30 May 2017

File No: R/2017/20/A
Our Ref: 2018/272277

Intercontinental Hotel and Transport House Upgrade Concept Plan (SSD 7693) – Response to Submissions

SETBACK DIAGRAM | VIEW FROM NORTH-EAST

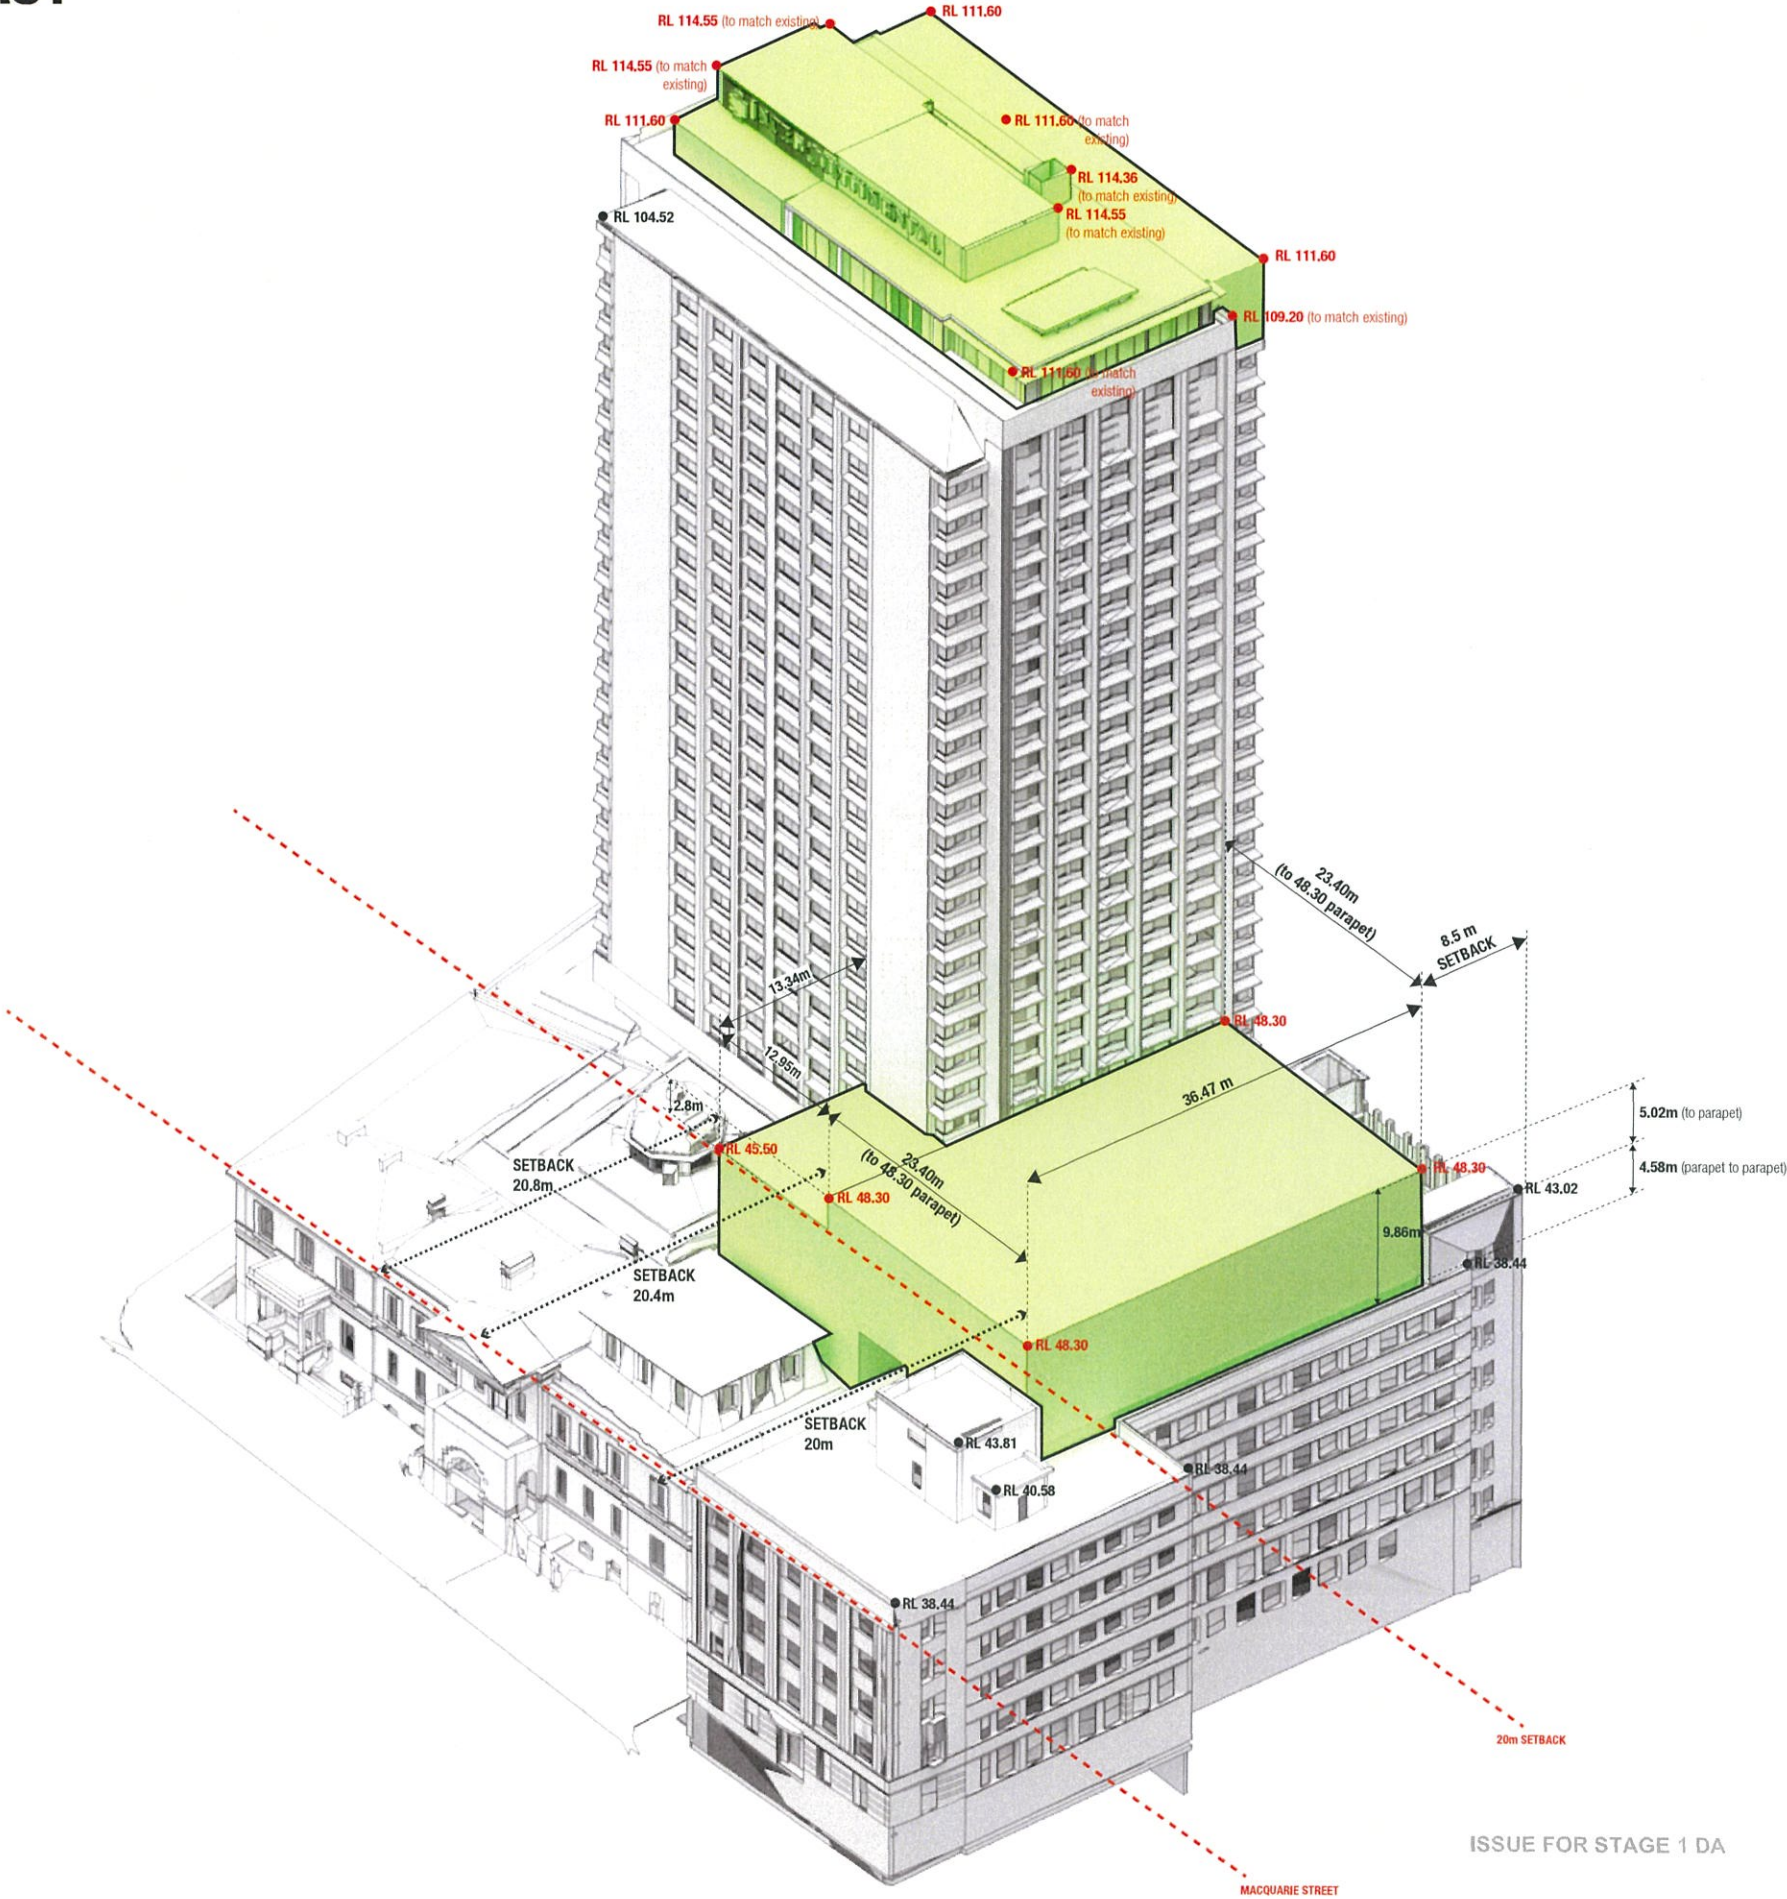
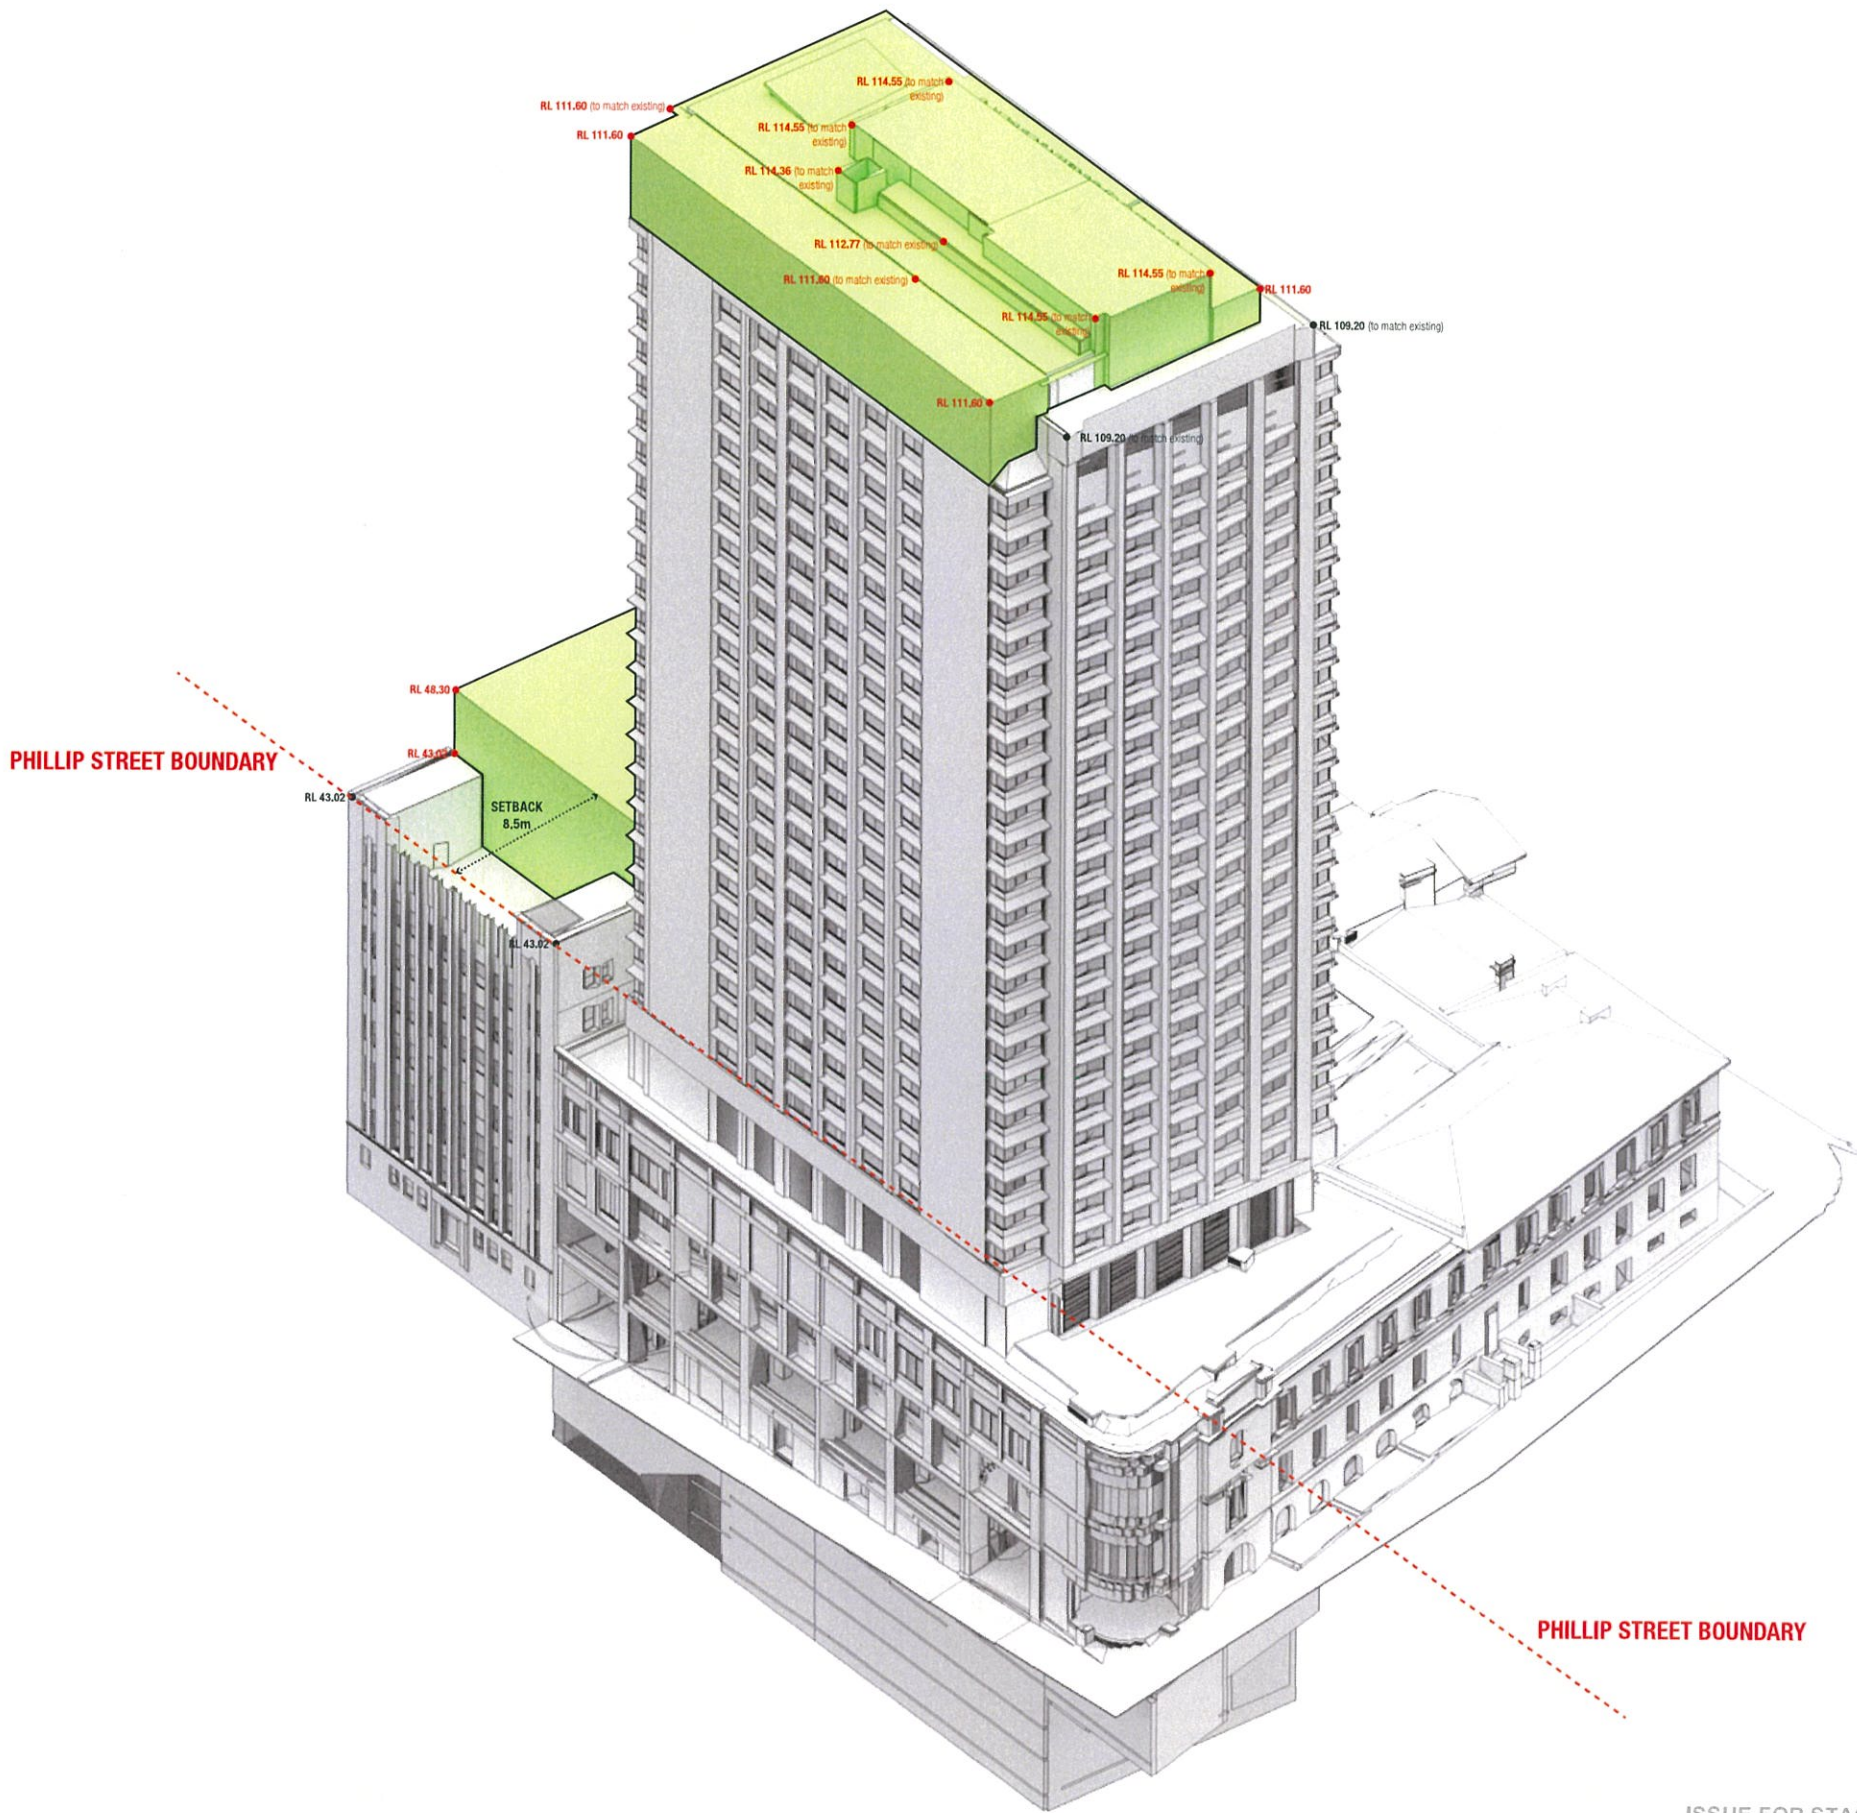
The key concerns raised regarding the lack of setbacks proposed and the height of the new addition over Transport House in terms of its impact upon the streetscape, the impact upon Transport House and upon heritage items in the vicinity have not been satisfactorily addressed or substantiated.
